SUBMISSION TO DEPARTMENT OF PLANNING

Application No MP10_0057
Location 132-138 Killeaton St, St Ives
Proponent Karimbla Properties (No.4) Pty Ltd
Council area Ku-ring-gai Council

SUBMISSION

DECEMBER – 21ST – 9AM

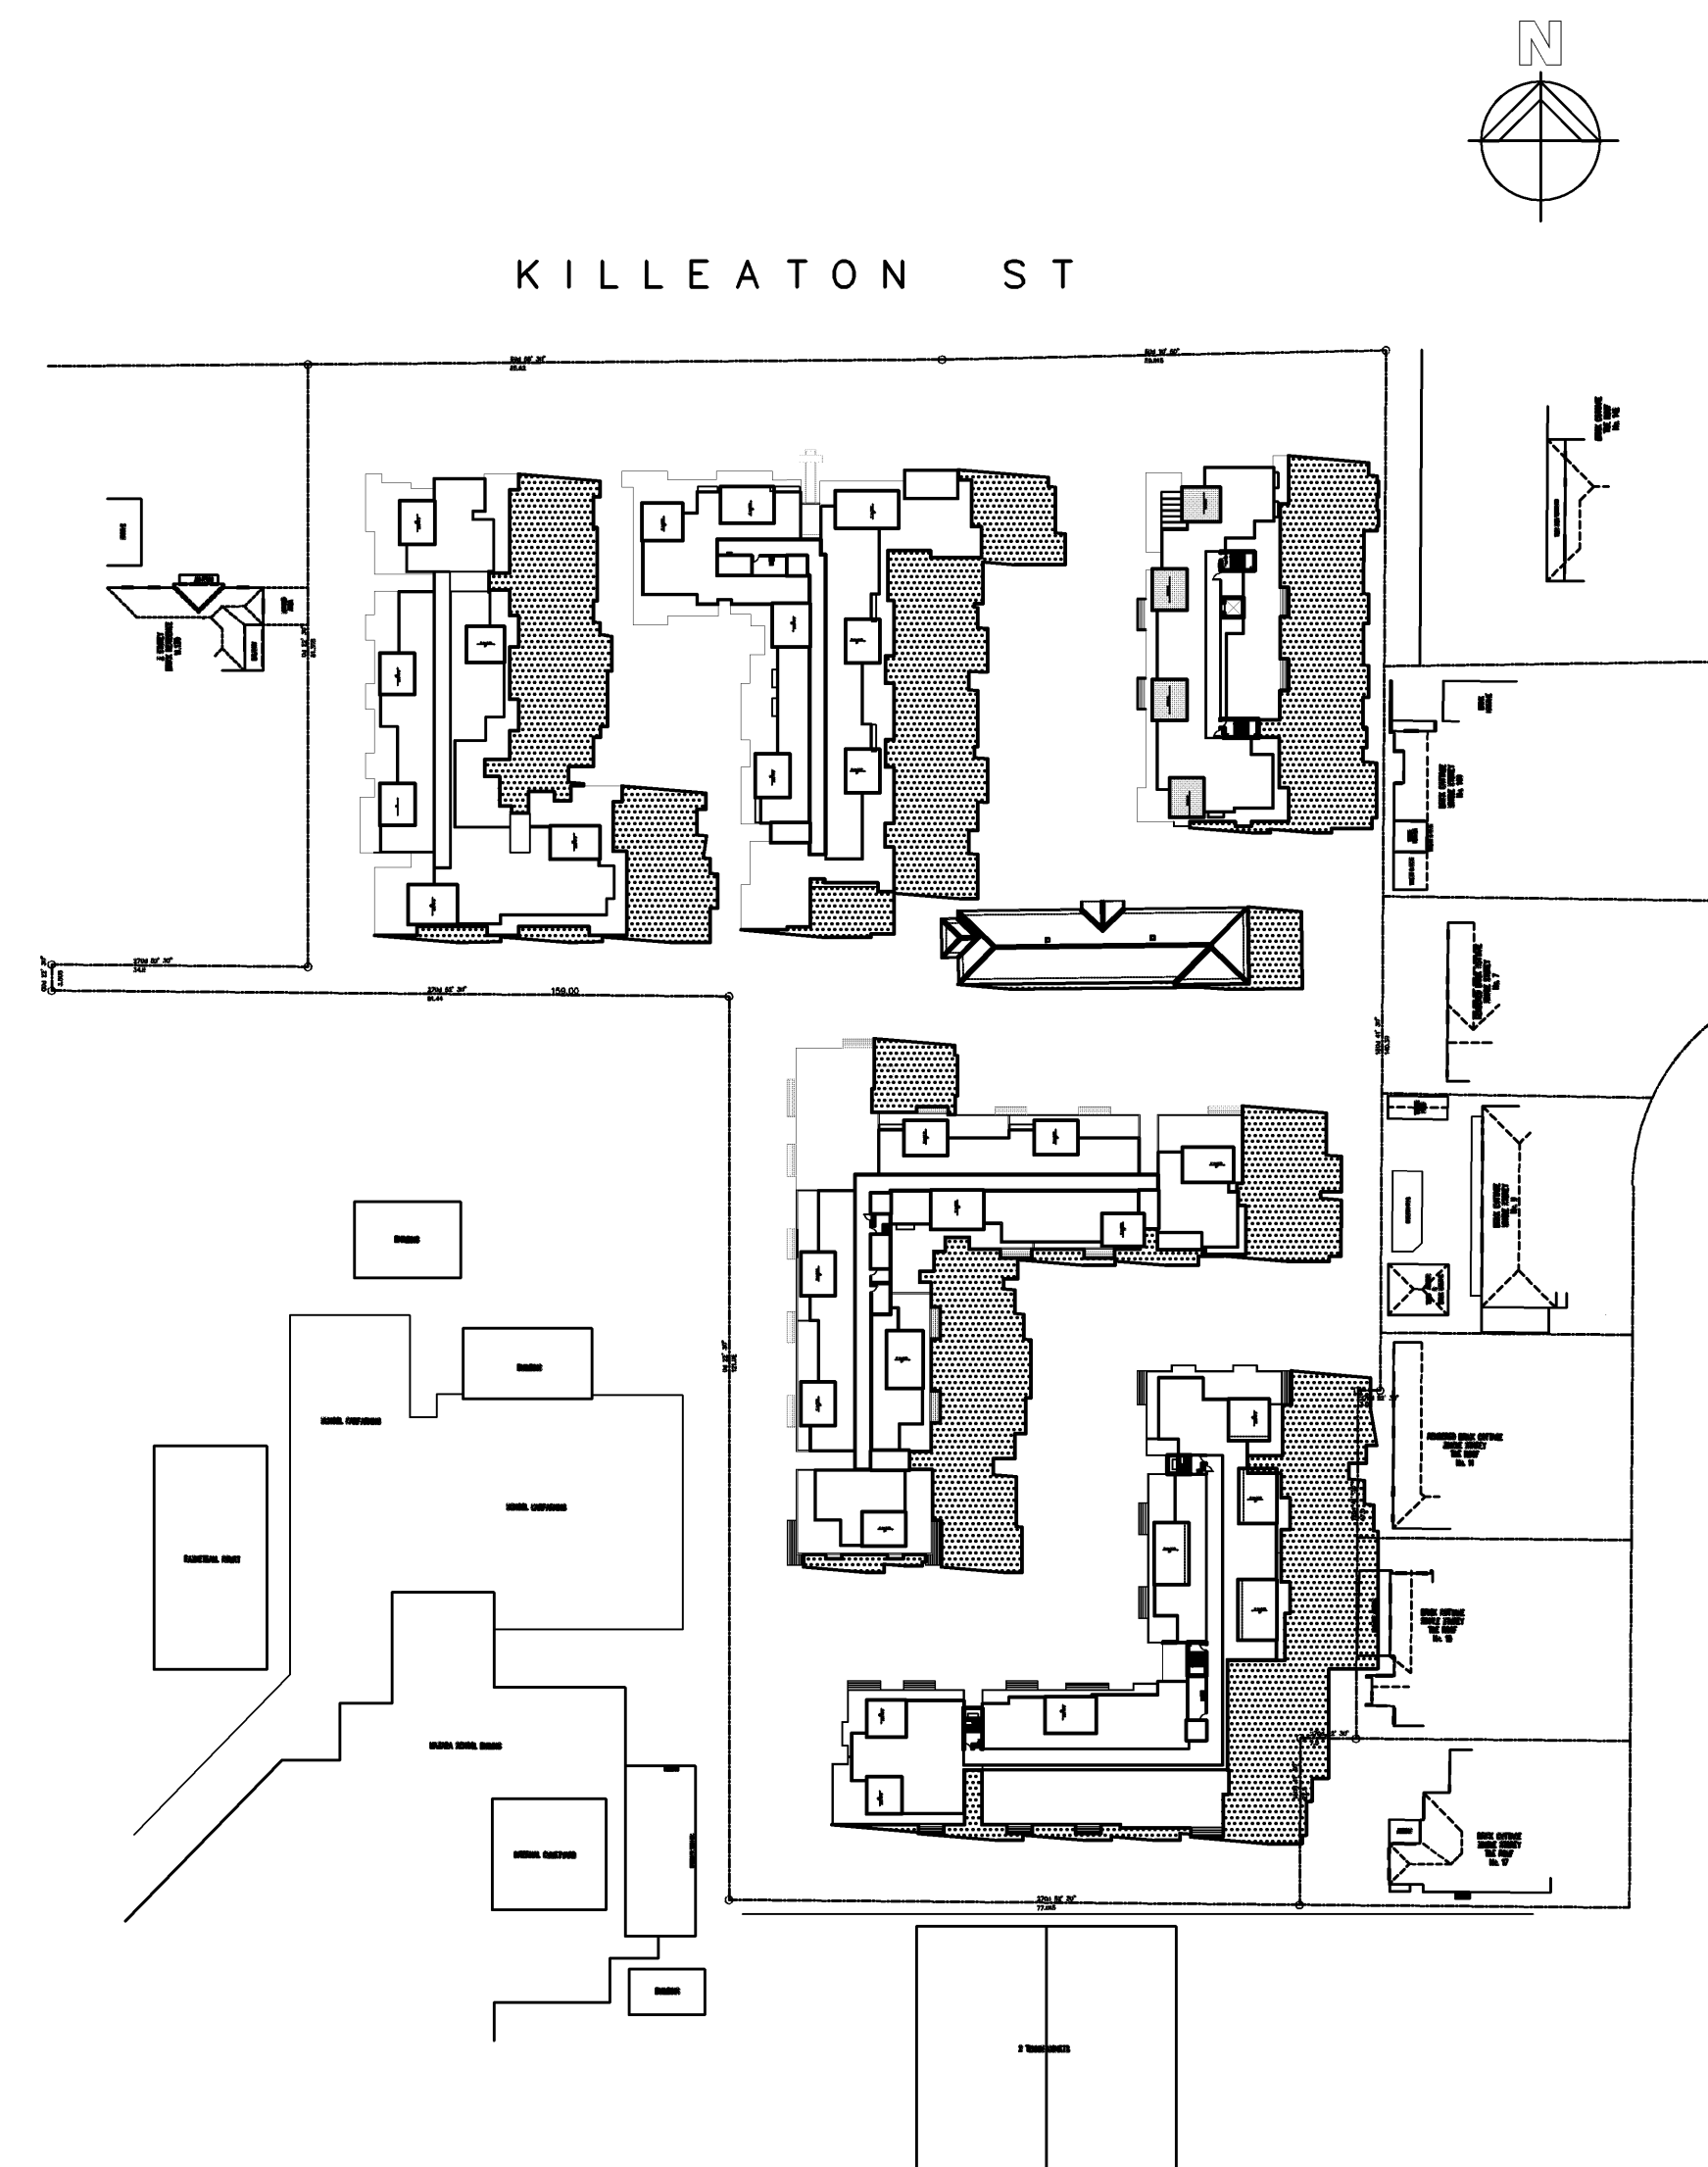
37. The shadow diagrams prepared by Meriton which are at Annexure 4 to the EA (Shadow Diagrams -1 [DA-70], Shadow Diagrams -2 [DA-71], Shadow Diagrams -3 [DA-72], Shadow Diagrams -4 [DA-73]), probably better reflect the impact on solar access and overshadowing that the proposed development will have on my house at 15 College Crescent, although it is still unclear whether even those diagrams take into account the natural relative topography of the Development Site and the College Street properties and therefore even those shadow diagrams probably understate the real impact that Building E will have on solar access and overshadowing on my house at 15 College Crescent. It is clear even from these Meriton Shadow Diagrams that by 3pm (and probably well before that time) on 21 June the whole of my house at 15 College Crescent will be overshadowed and have no solar access at all to the winter sun.

38. It is also clear from the Meriton Shadow diagrams, that in order to minimise the adverse impact on solar access and overshadowing, what is required is that Building E be repositioned at least 24 metres from my house. It is instructive that for the purpose of providing adequate solar access to the apartments in the development the Applicant has provided for a distance of about 24 metres between Building D and Building E. Therefore the Applicant is achieving an acceptable solar and overshadowing environment for the apartment in the development but at the expense of the amenity of my house at 15 College Crescent.
